Application for a Non-Material Amendment Following a Grant of Planning Permission

Construction of a head house and associated hard and soft landscaping and provision of a temporary access from Welling Way. (Re-consultation due to departure from the Development Plan

18/4264/F

The proposed design amendments for the Eltham headhouse are the outcome of progressive detailed design development of the Approved Design.

001 Ground Level
1 : 100

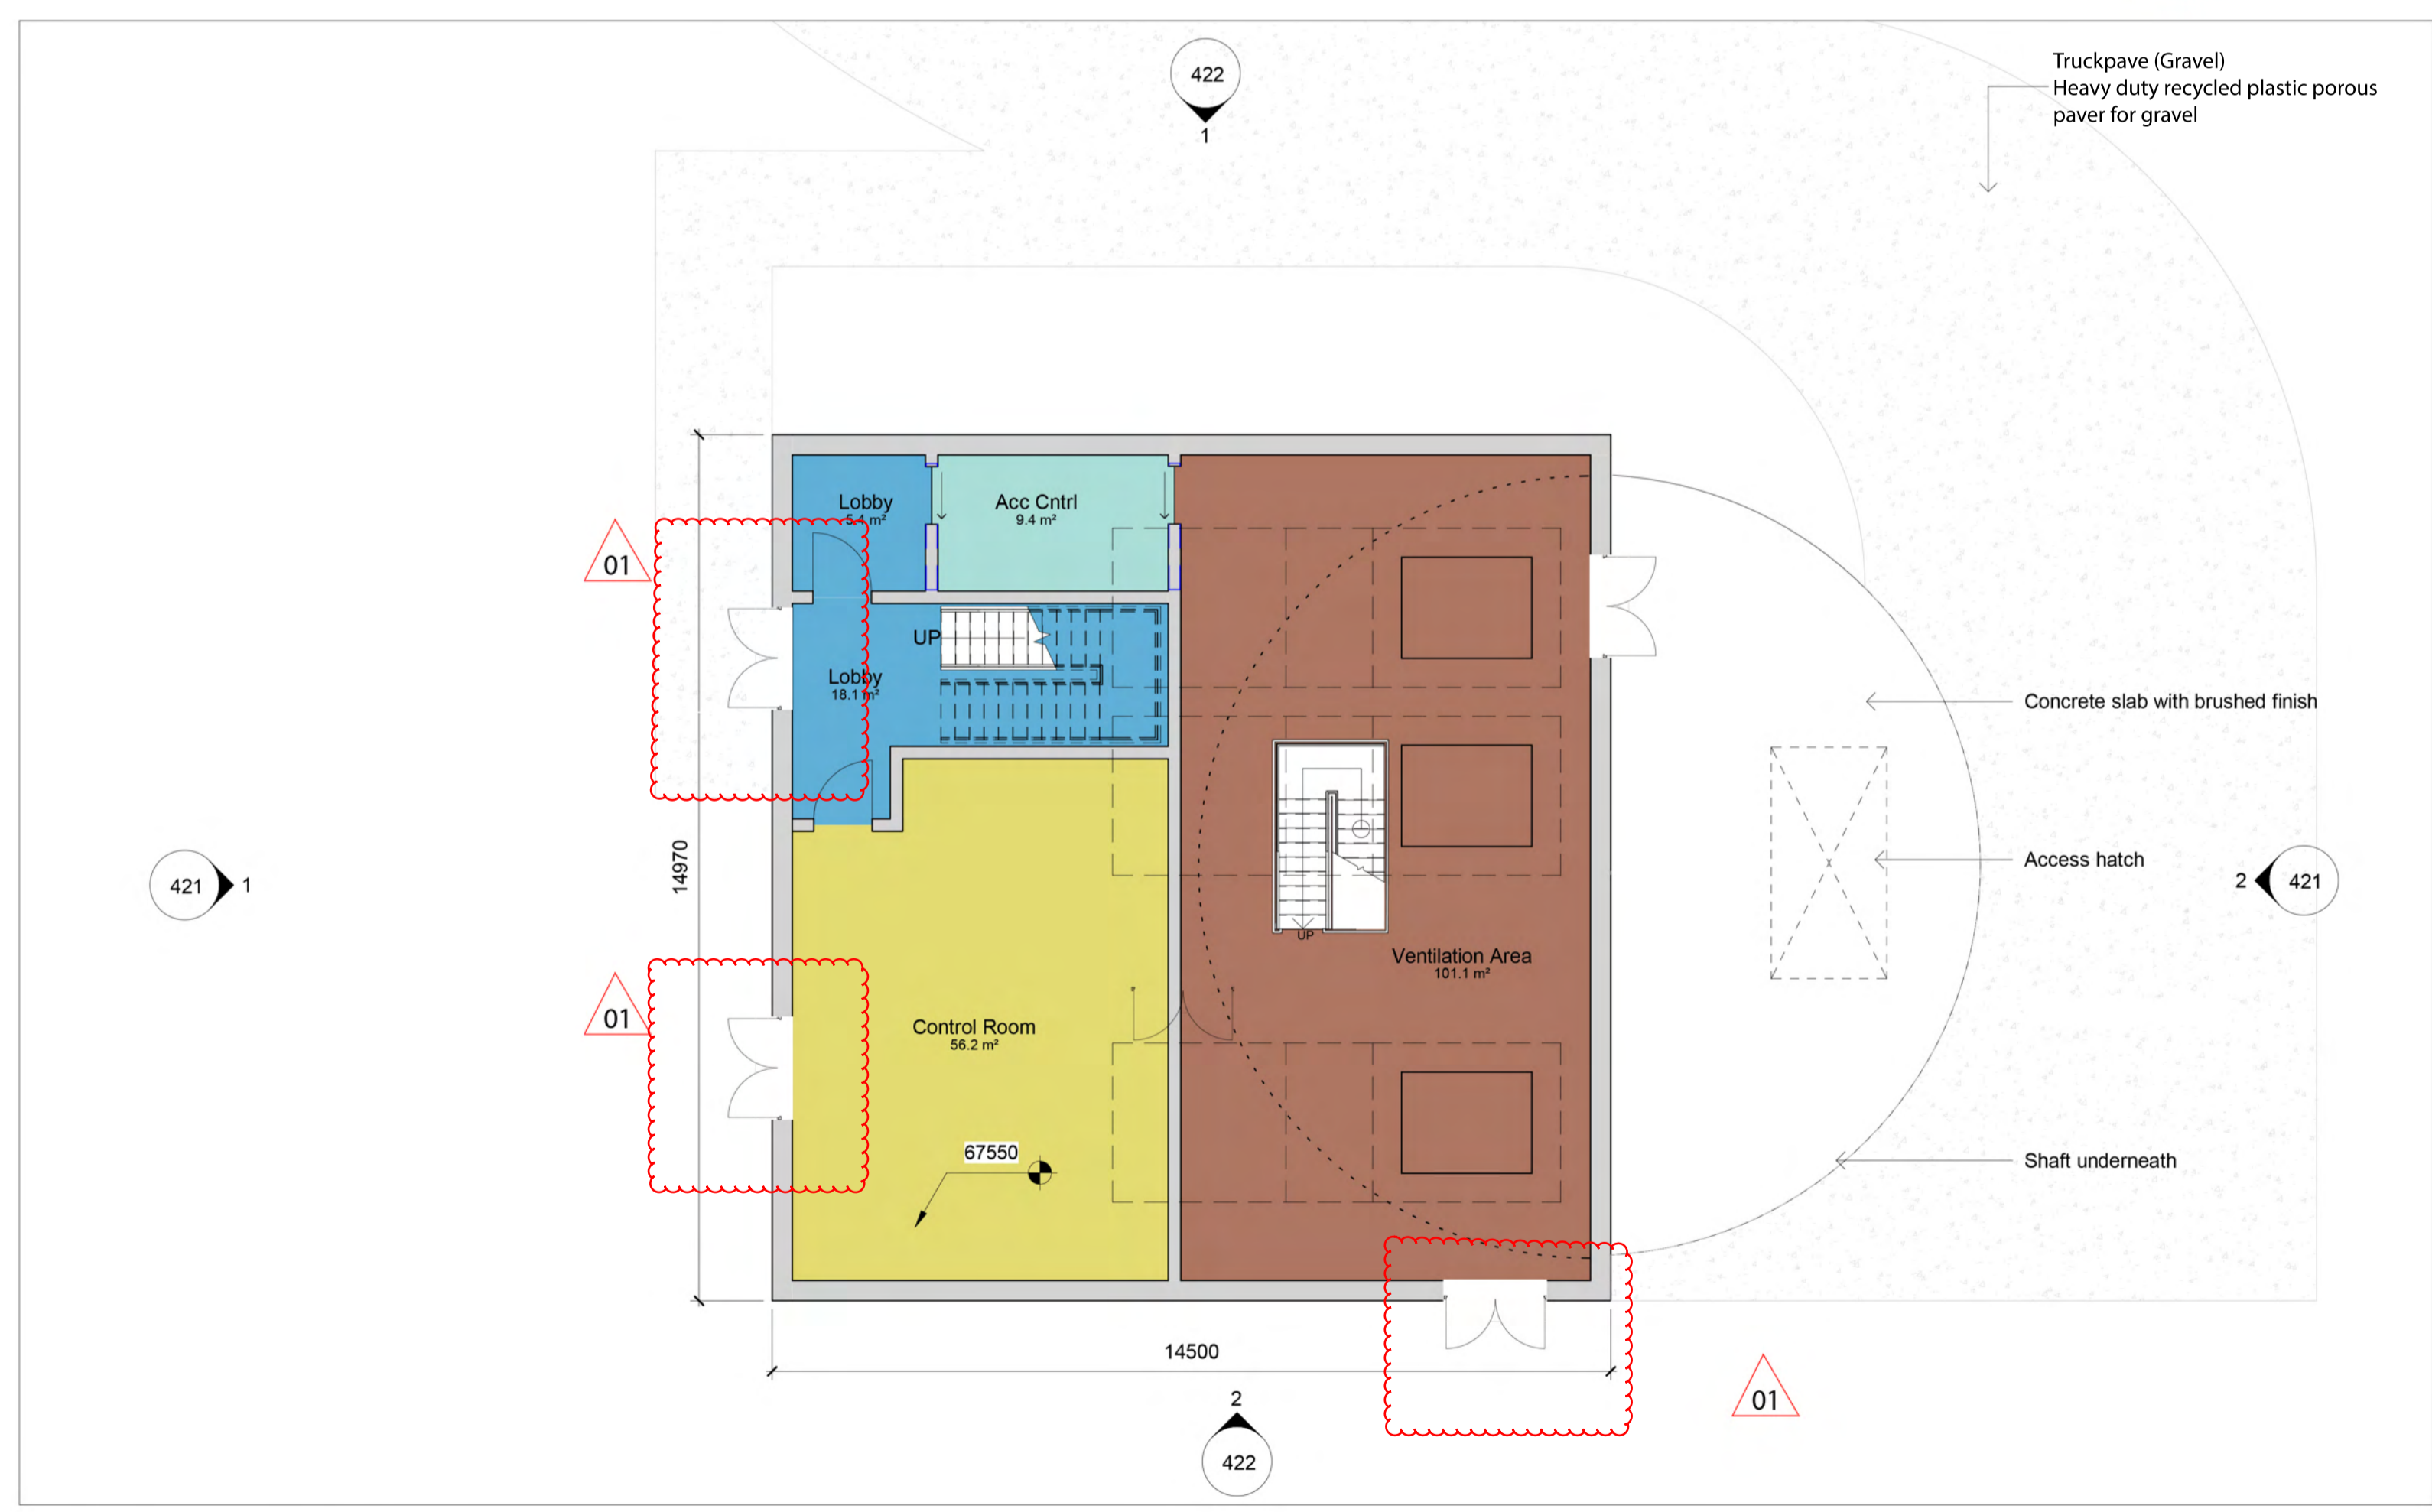
The technical design development of the mechanical ventilation systems has been resolved through the incorporation of specific equipment from manufacturers such that the overall size of the equipment (e.g. fans and ducts) has been slightly reduced compared to the spatial allowances provided in the Approved Design. Consequentially, the mezzanine level has been reduced in footprint, the external louvre area has been reduced and the East Elevation of the building (the lower side of the roof) has been slightly increased in height.

Closer integration of National Grid's functional requirements has resulted in the introduction of additional doors at ground level (on West and South Elevations).

The description of the Green roof on drawing PDD-11524-ARC- 403_02 has been clarified as a Brown Wildflower type, rather than Brown Wildflower/Sedum. This is in line with the approved Ecological Management Plan (LPT2-HMV-TUN-ELTH-PLN-EN-250004) that was included in the submission associated with Decision Notice 21/0531/SD and provides a significantly greater level of biodiversity compared to Sedum.

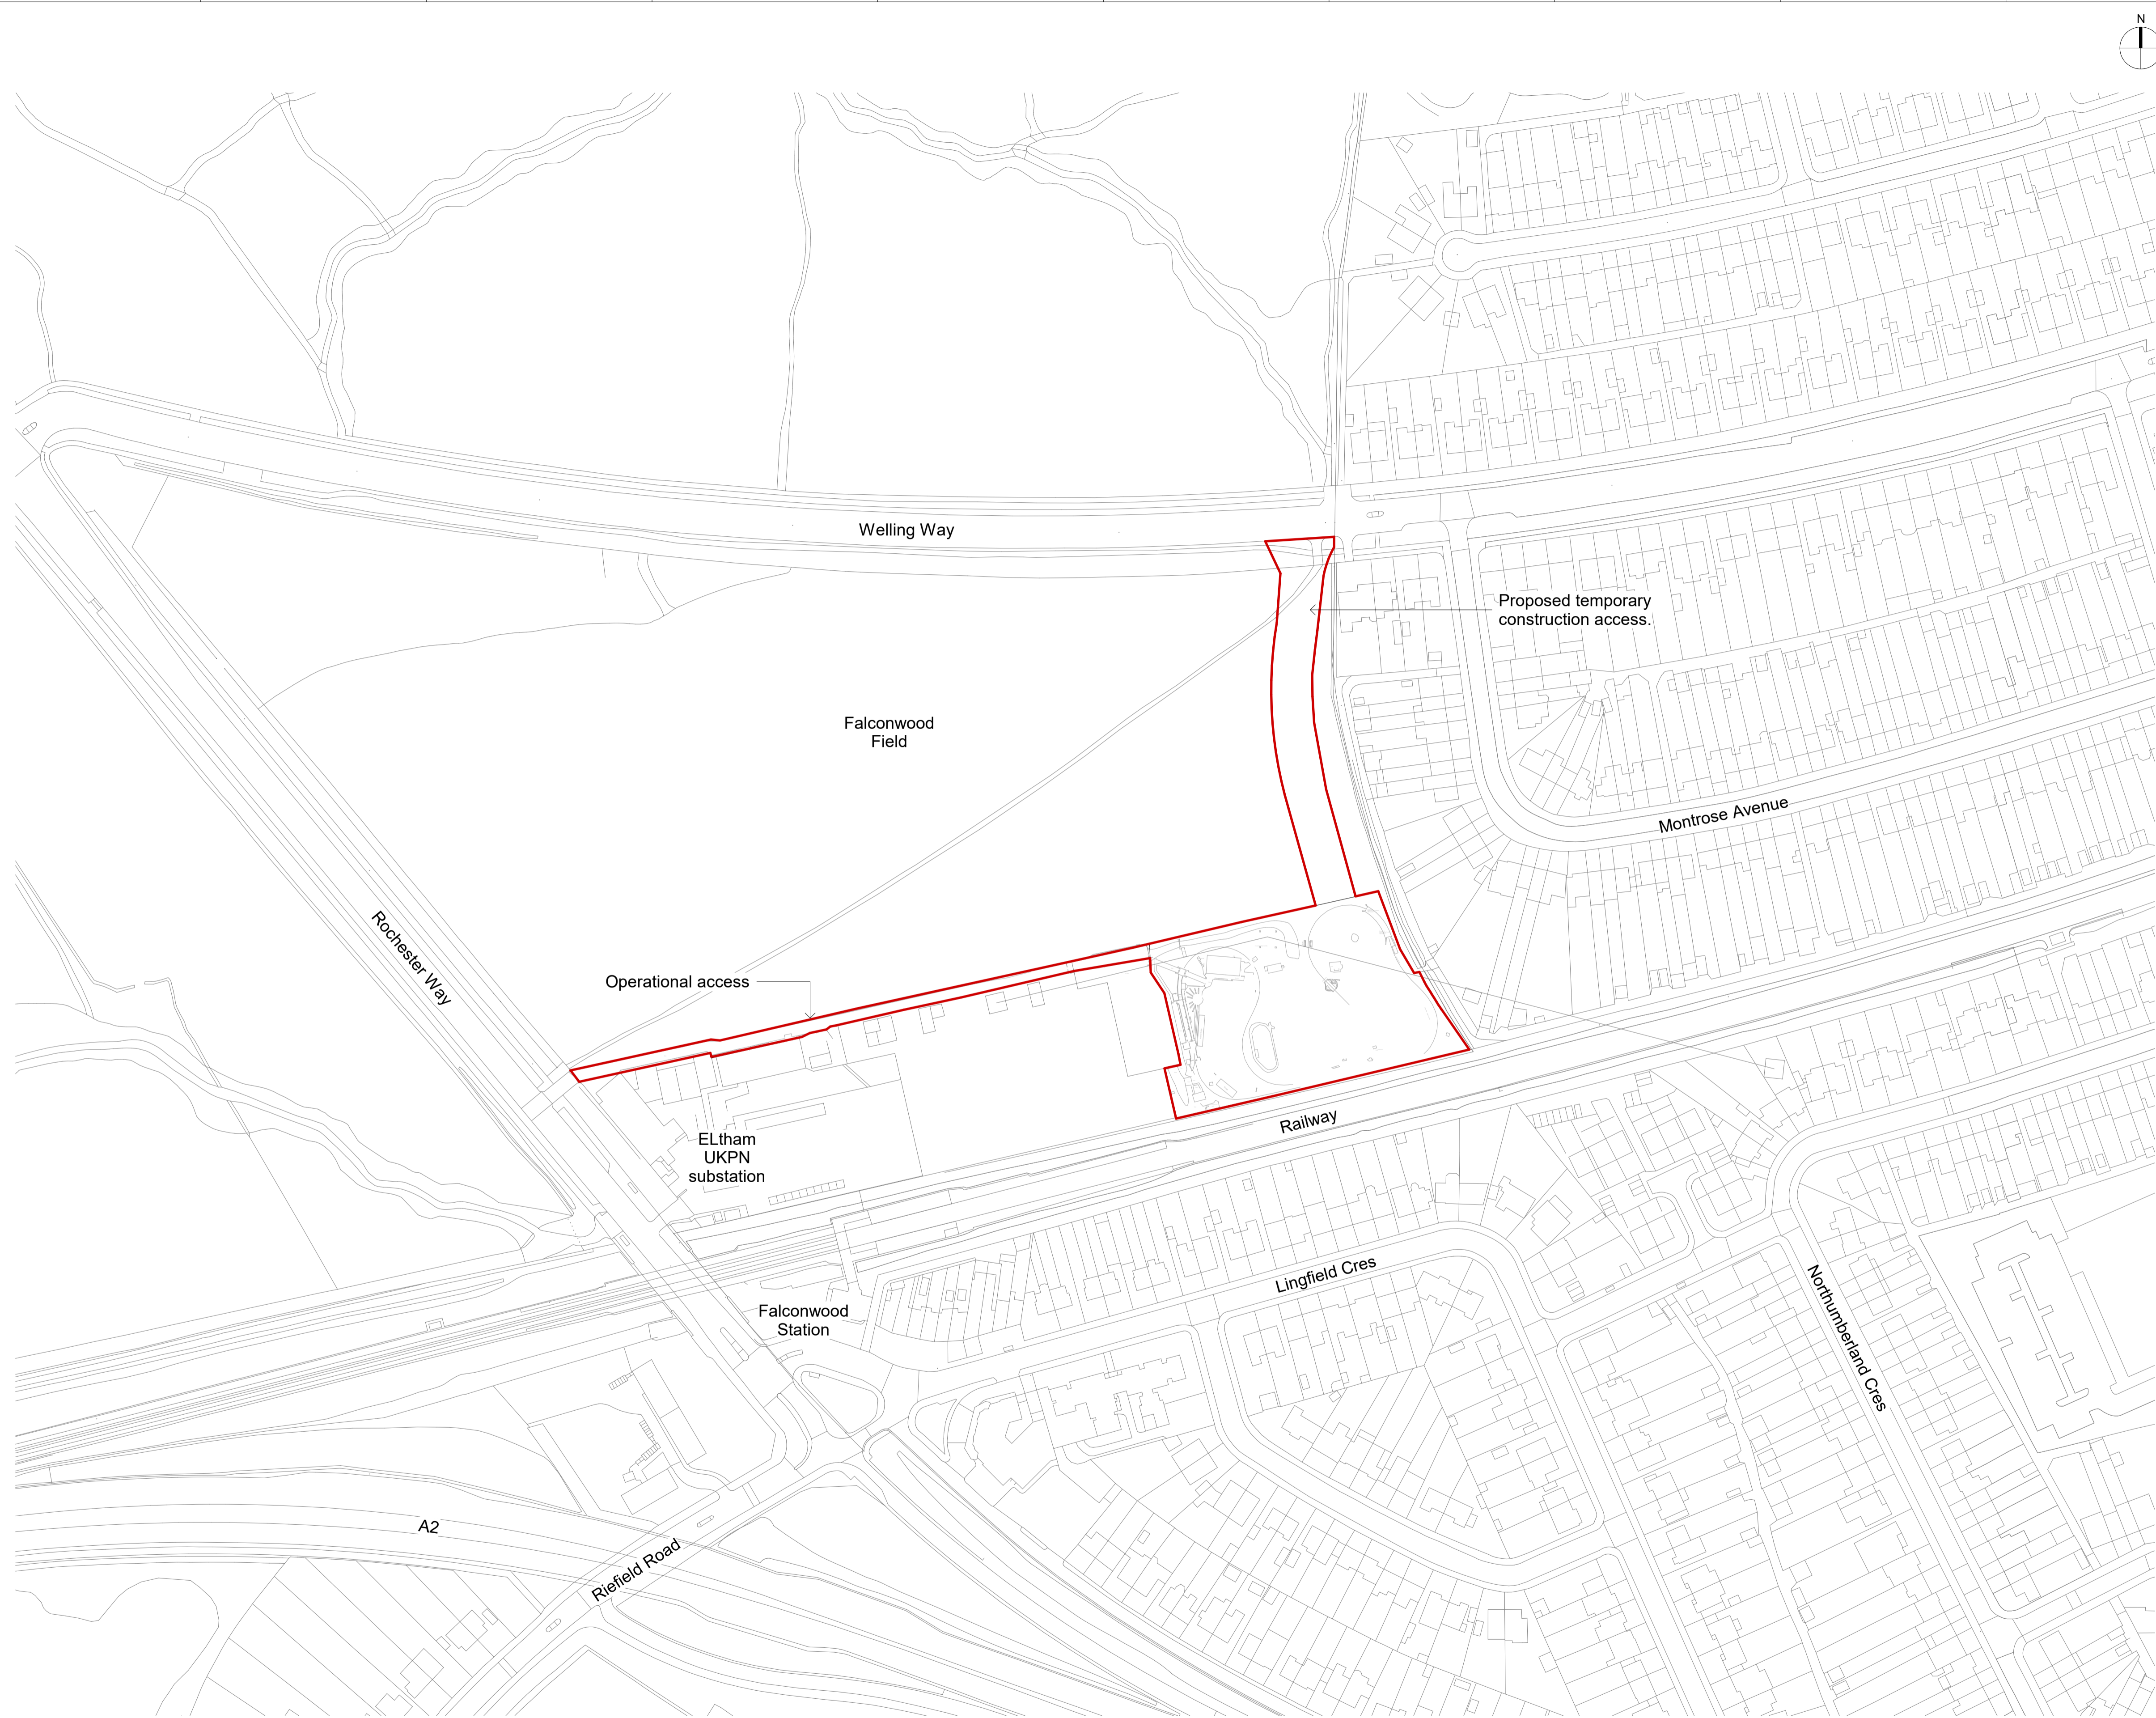
Road access within the site has been optimised for safety. Where practicable, turning circle radii have been reduced for better visibility and provision for reversing of vehicles has been incorporated.

Addressing Decision Notice 23/4043/NM, the revised plan PDD-11524-ARC- 403_02 provides clarification of surfaces noted in the approved design as "hardstanding" and indicates the demarcation between Truckpave road access and proposed concrete paving surrounding the headhouse building.

The Truckpave product (with gravel infill) is a permeable surface. The concrete paving provides a suitable access and egress route for all weather conditions and will permit equipment to be brought in and out of the headhouse.

Please note that the soft landscape design (including any information pertaining to trees) indicated on drawing PDD-11524-ARC- 403 is superseded by the design information associated with Decision Notice 21/0531/SD. Drawing PDD-11524-ARC- 403_02 has been updated to provide reference to Decision Notice 21/0531/SD.

The approved Tree Protection plan (Page 23 within document LPT2-HMV-TUN-ELTH-RAM-HS-250007: Arboricultural Method Statement Eltham) included in the design submission associated with Decision Notice 21/0531/SD indicates that all trees shown on drawing PDD-11524-ARC- 403 are to be removed. Therefore, the proposed re-configured permeable road will not result in any additional tree loss.
